**Planning Application, Ribble Valley District
3/11/0534 17-17A Accrington Road, Whalley**

I am recommending refusal of this application on highway safety grounds.

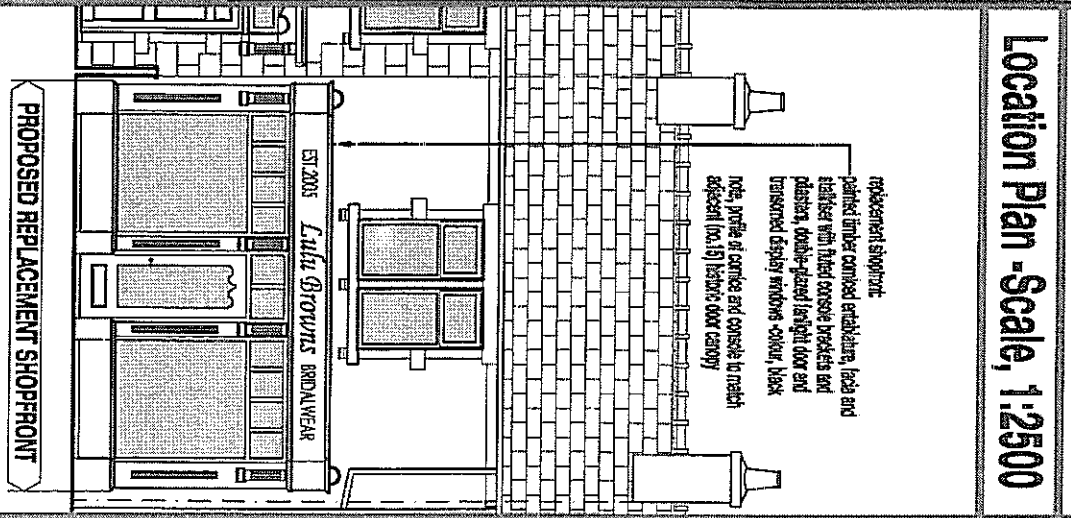
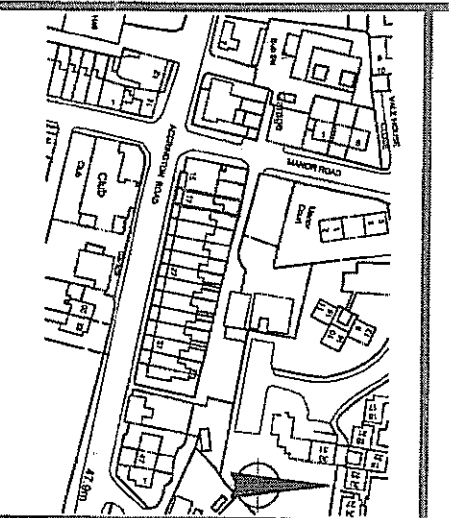
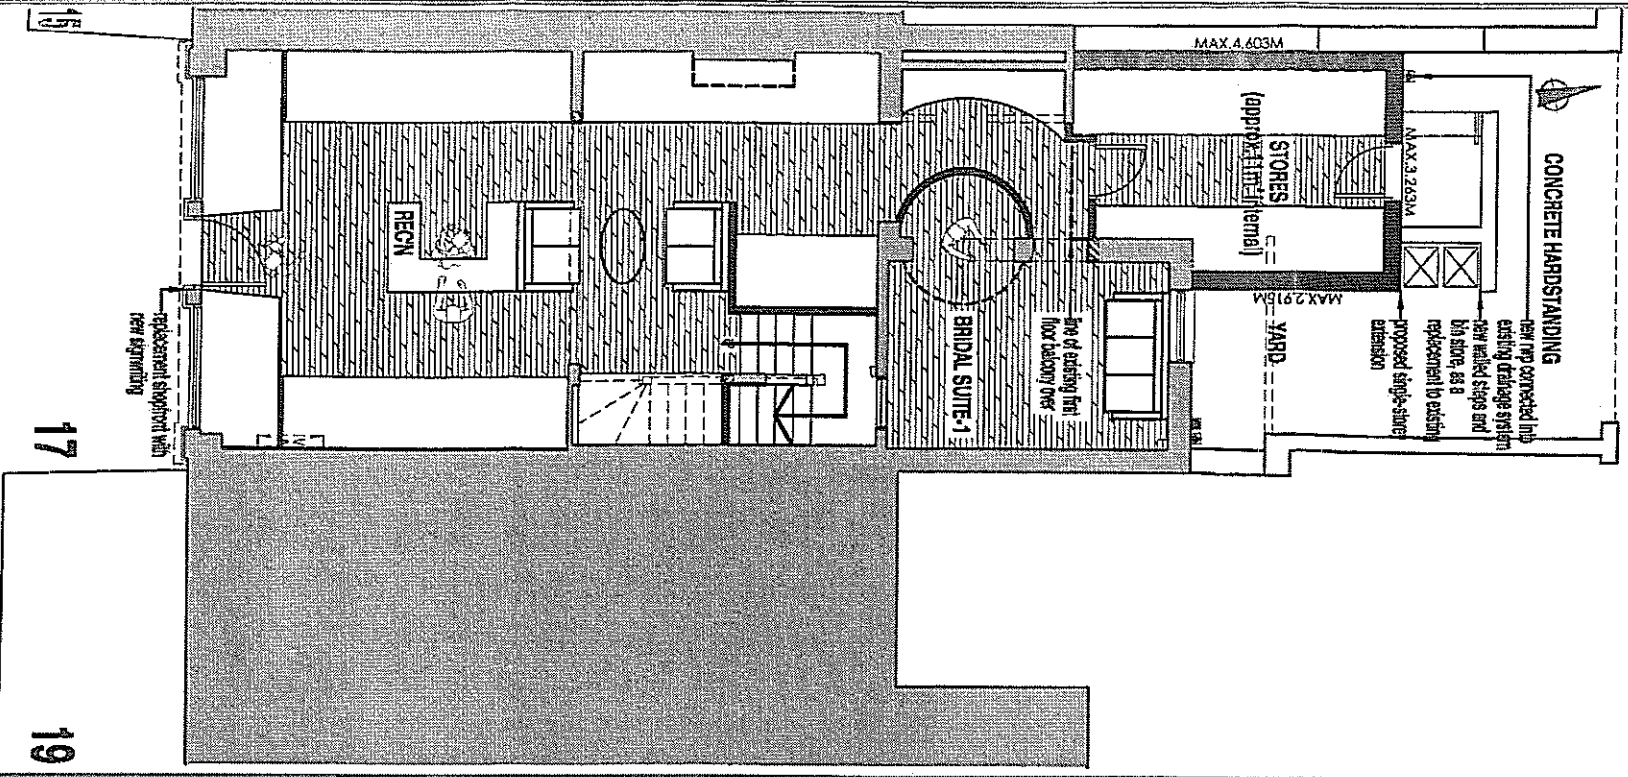
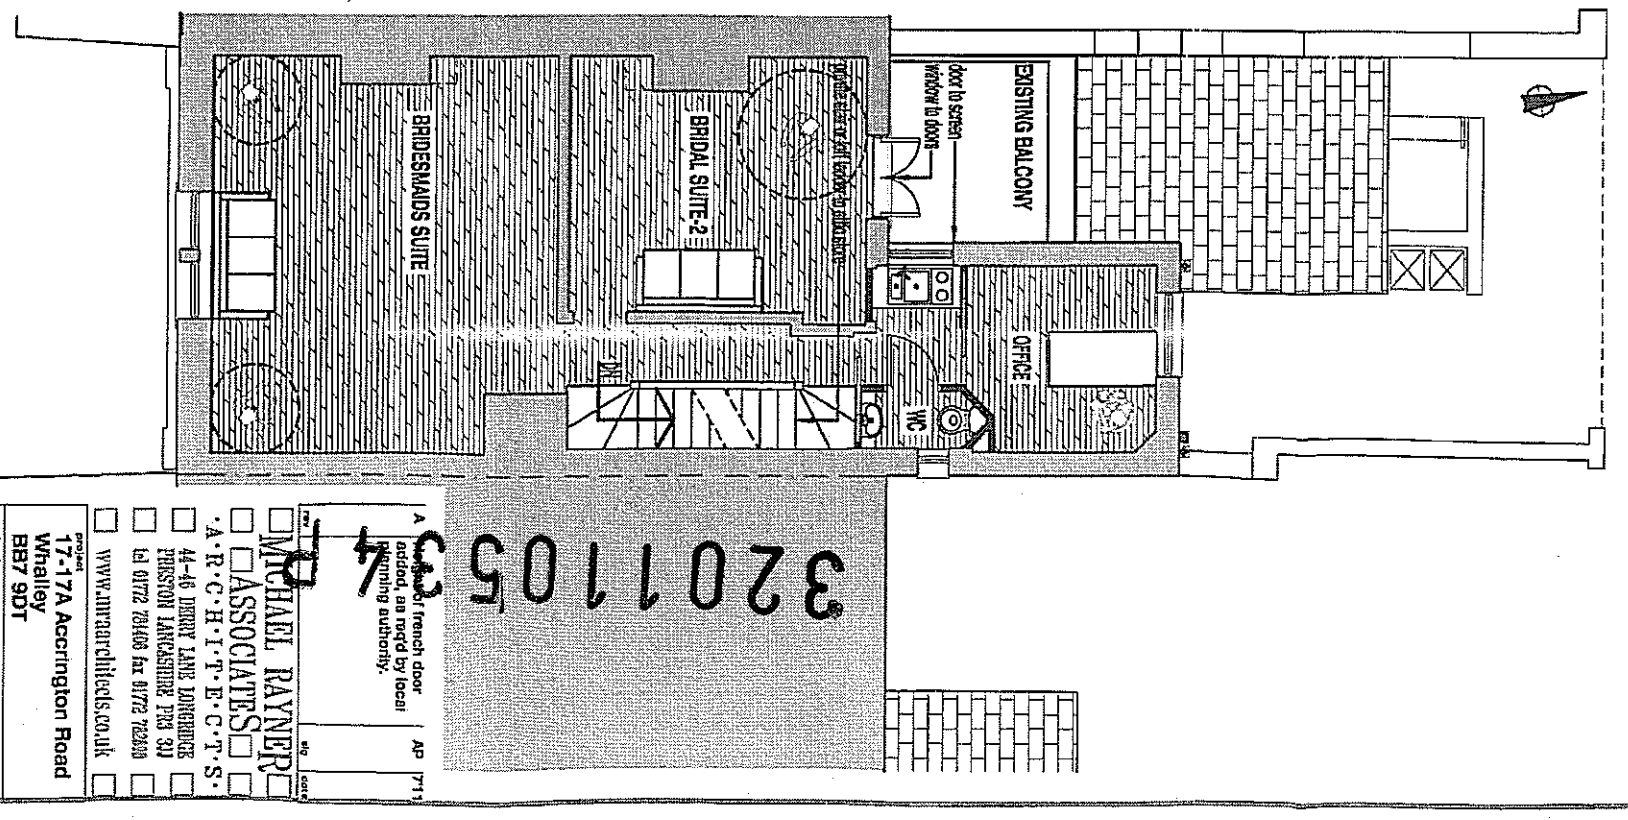
The alterations to the rear of the property will result in the loss of one off street parking space. As there is already a high demand for residential and visitor parking in this vicinity, I am concerned that the additional demands of staff (2 full time equivalent) and customers, are likely to increase the demand for parking on Whalley Road and Manor Road.

My concern is that the demand for on street parking as a result of the proposed development will increase, with the result that there is the potential for displaced vehicles to be parked on Whalley Road and Manor Road, to the detriment of highway safety.
